COMMENTS

CBL: 340-F-001

Permit: 000673  
Pool → Closed 7/10/2000

Pool 12x20  
Oval

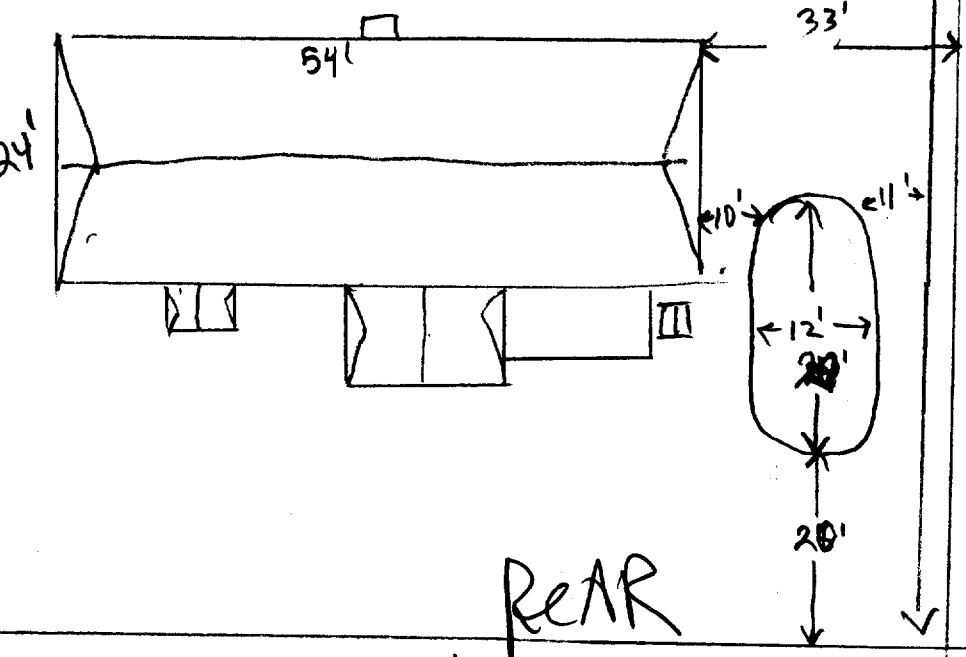
7-5-00 Pool pre con w/ steve w/ owner. checked setbacks - need more information on paper street - this pin seems to line up with the curb. Called owner to verify pin placement and get a deed to verify property dimensions, he says there is another pin at the right rear corner. Reviewed code requirements for pools & barriers - also for electrical permit. JB

7-7-00 Spoke w/ Robert Cohen - he says there is no other monumentation on the Broadway side of his property, therefore we cannot determine his line in relation to the paper st. He is going to get a copy from register of deeds of his property and come in to discuss his options. JB

7-10-00 Owner will Amend Permit to Relocate JB  
Closed 10/5/2000
